## CONSULTEE RESPONSE (Arun District Council - Arboriculturist)

Reference: BN/33/26/PL

Proposal: Construction of 2 No C2 (residential institution) dwellings and associated works (resubmission following BN/125/25/PL). This application may affect the setting of a listed building and is in CIL Zone 2 and is CIL Liab as new dwellings.

Location: Land South of The Hollies, 84 Barnham Road, Eastergate, PO22 0ES

DRAWING TITLE: **DRAINAGE STRATEGY**

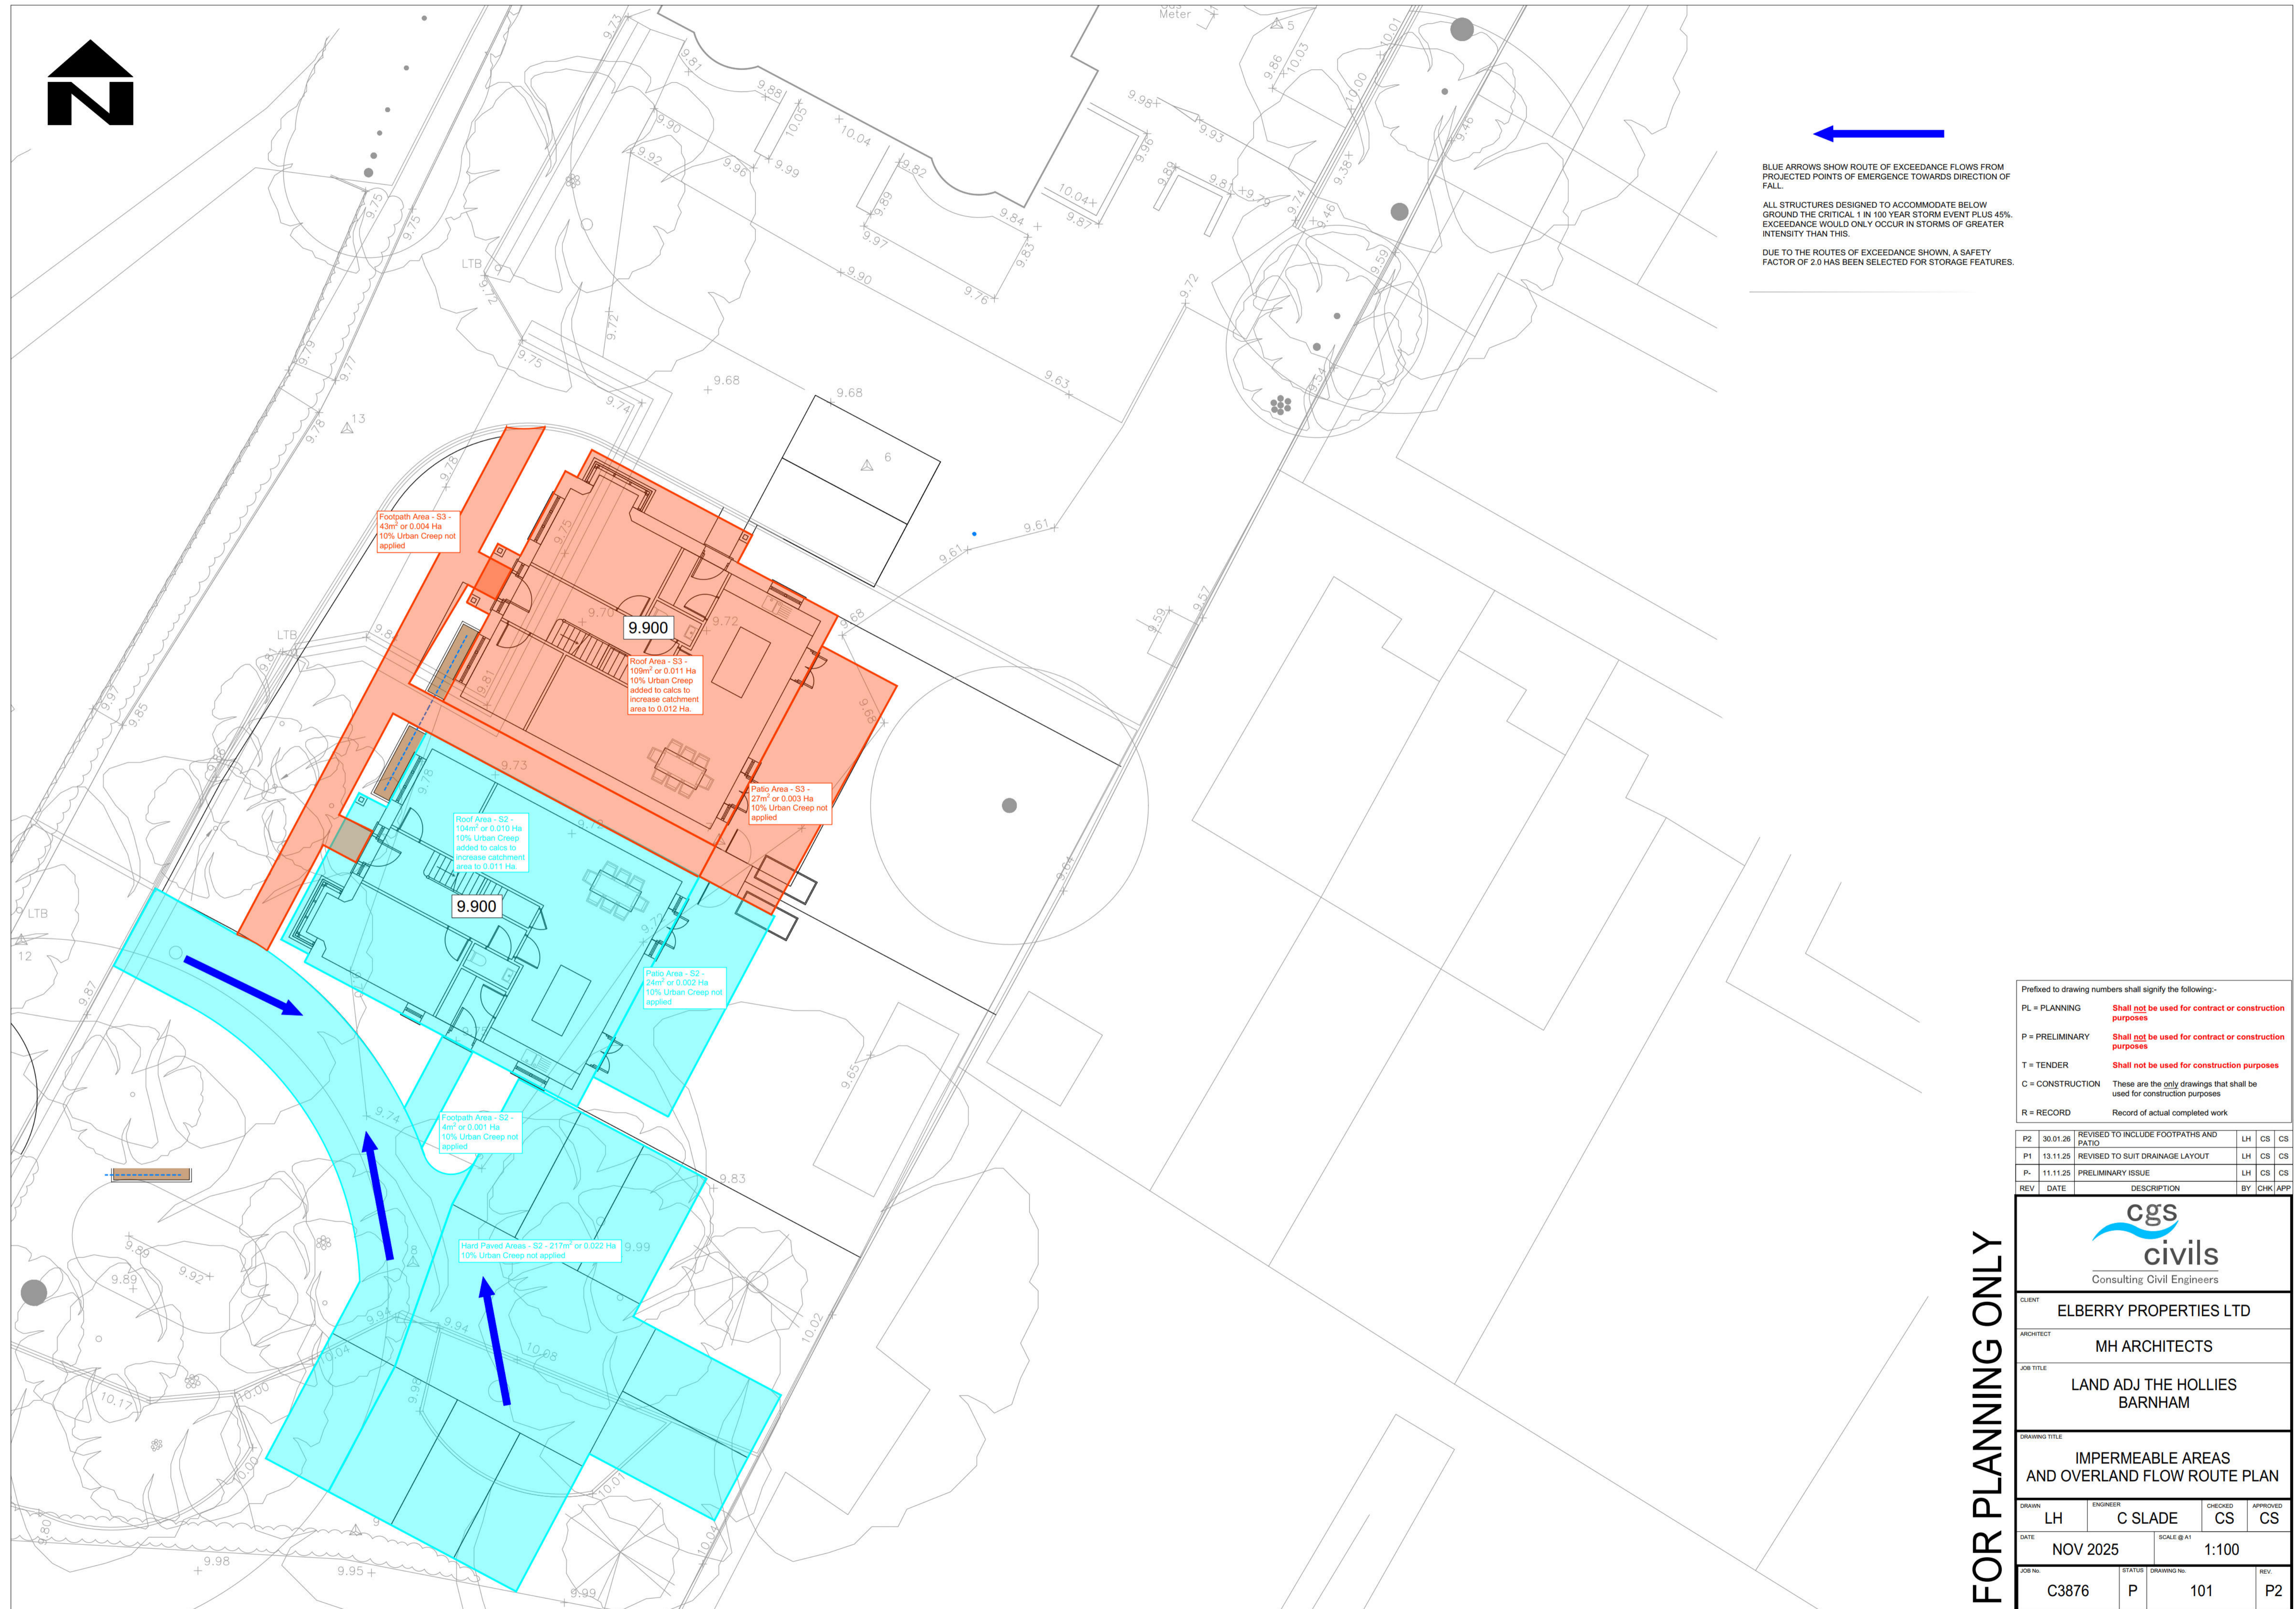
The location of attenuation tanks at the rear of both plots abuts the root protection area (RPA) of T8 Ash, which fails to recognise its growth potential and puts that structure at risk of conflict. Our drainage engineer could be best placed to consider the integrity of such a structure against the direct physical pressure and exploitative capacity of an expanding tree root system.

The rear garden of plot 1 is burdened with the bulk of required attenuation feature, again abutting the RPA and potentially limiting exploitation of that space.

Our drainage engineer may need to consider the lifespan/integrity of the attenuation tank feature given the high growth potential and future presence of mature tree(s) in the rear garden of plot 2.

Appendix 1 - Tree Retention & Protection Plan

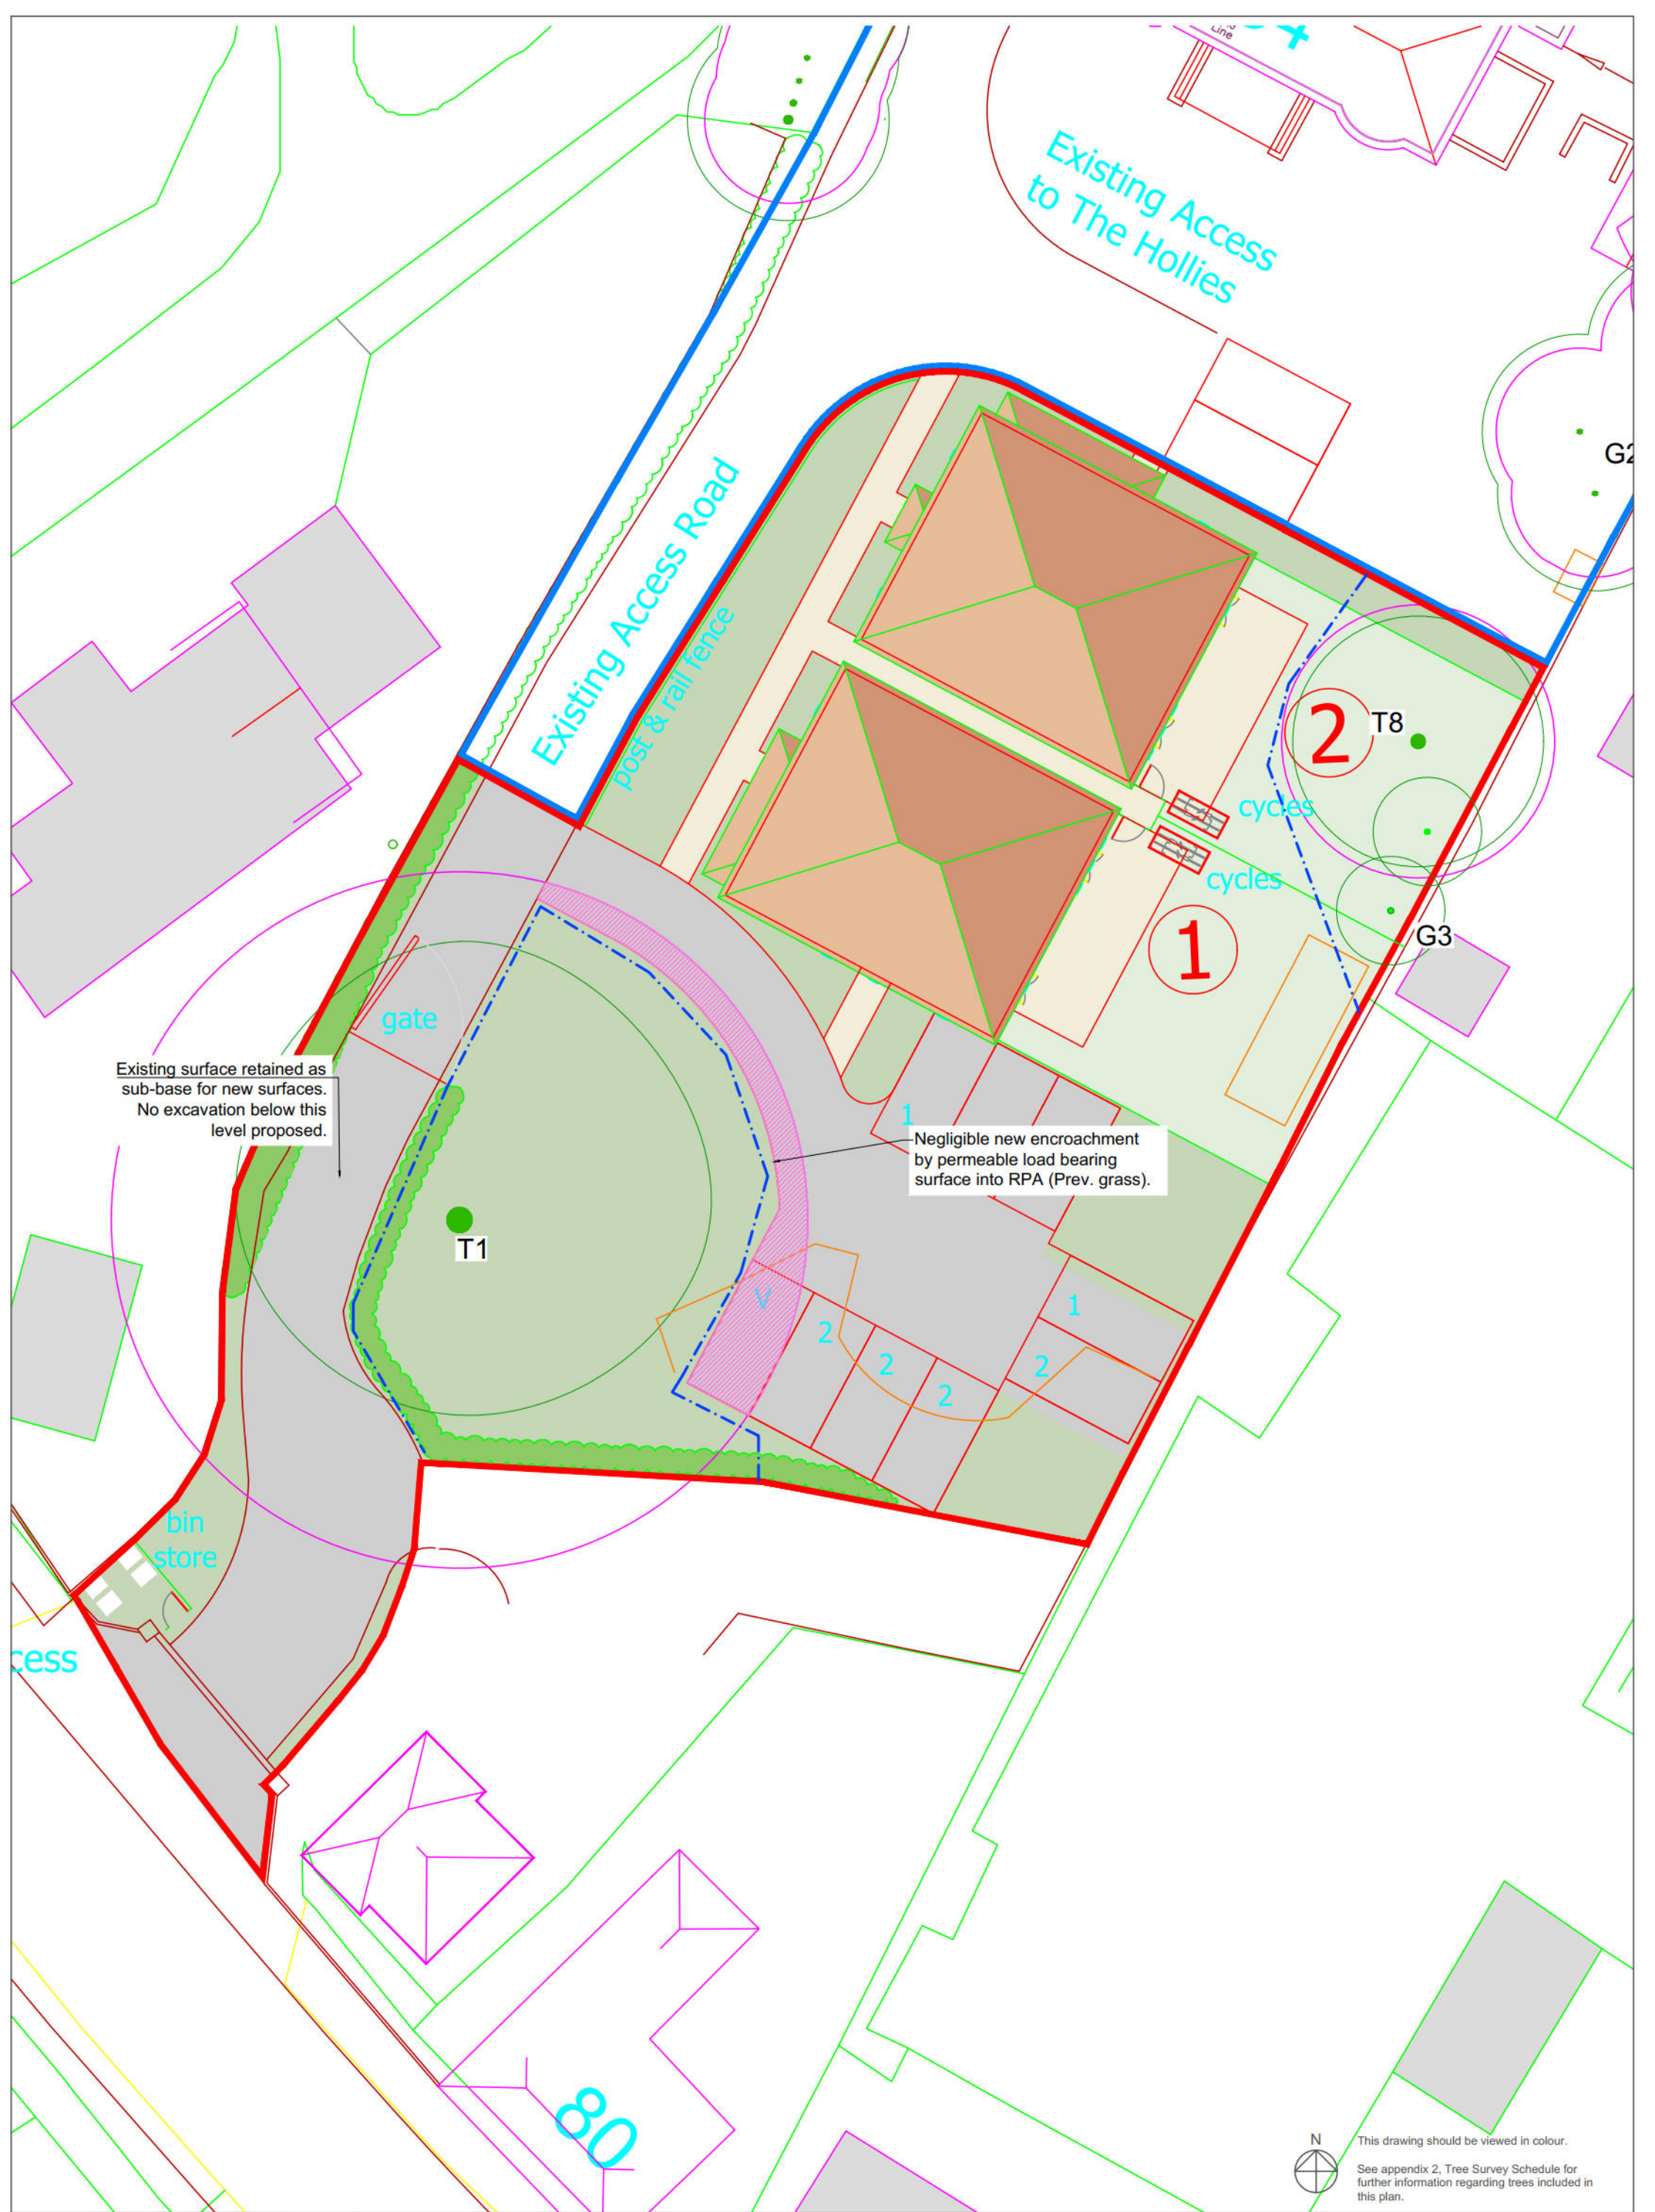
The proximity of proposed dwelling at plot 2 to the existing crown of T8 could easily be perceived as nuisance or hazard forming, also with shade cast across the property for much of the day and set to increase if growth potential is reached.

The extent of RPA overlapping usable garden space of plot 2 requires a restriction be placed on permitted development rights (PDR) to outside of its perimeter, to preserve the soil structure and prevent harm occurring from excavation, compaction or contamination.

The above areas of conflict should be 'designed out' and a more sympathetic layout proposed to better accommodate T8 ash, the subject of a tree preservation order.

With the proposed change of land use, it is necessary to restrict permitted development rights within plot 2, to prevent building works impacting the root system of a protected tree.
